Your ref: MP09_0146
Our Ref: TP/3(8).04

9 May 2013

**PREFERRED PROJECT REPORT (RESPONSE TO
SUBMISSIONS) – MIXED USE DEVELOPMENT AT
EASTLAKES SHOPPING CENTRE, EASTLAKES (MP09_0146)**

SCALE: <b>1:200 @ A1</b>	CHECKED: <b>RB</b>
PROJECT NUMBER: <b>11001</b>	DRAWING NUMBER: <b>DA 15</b>
	ISSUE: <b>D</b>

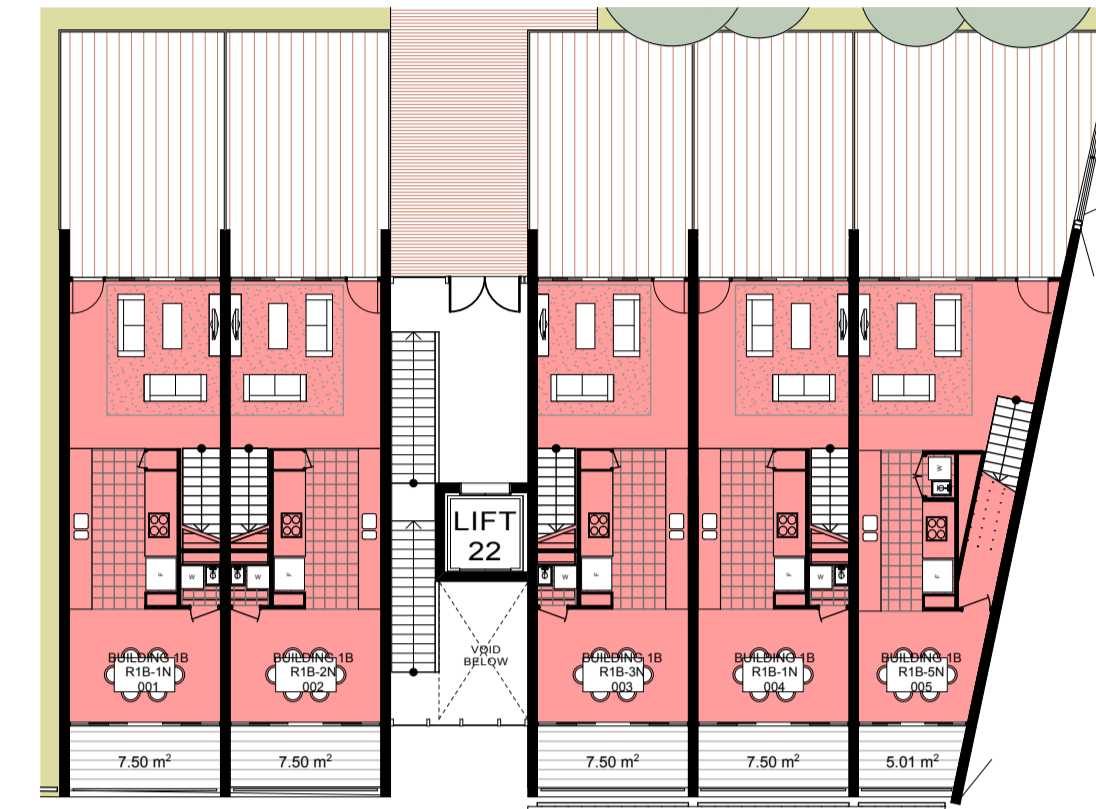
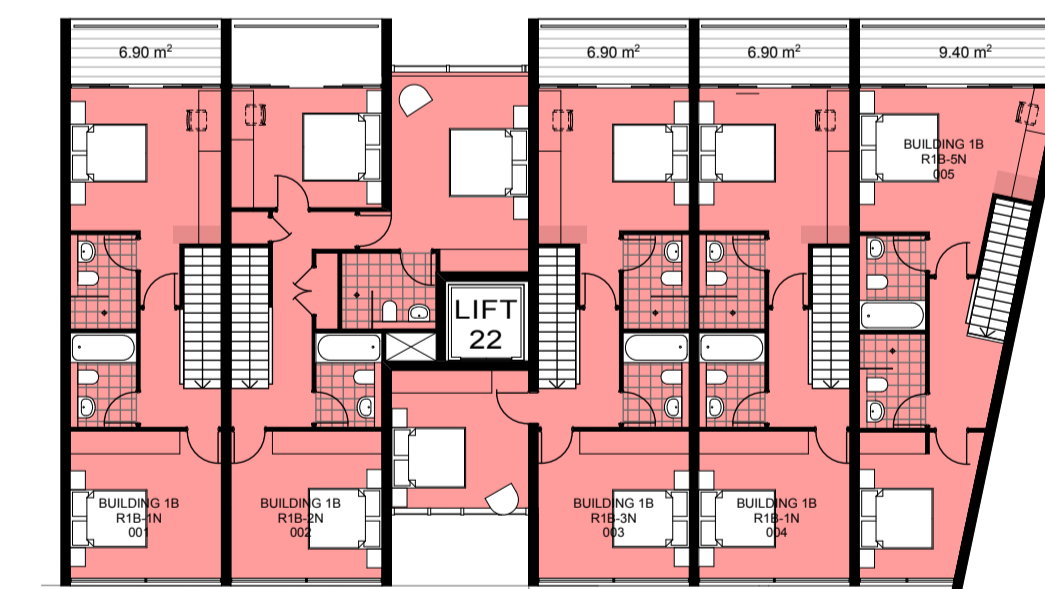
The southern half of Building 1A should be lowered by at least 2 storeys to reduce visual impact and overshadowing of the south side of Evans Avenue.
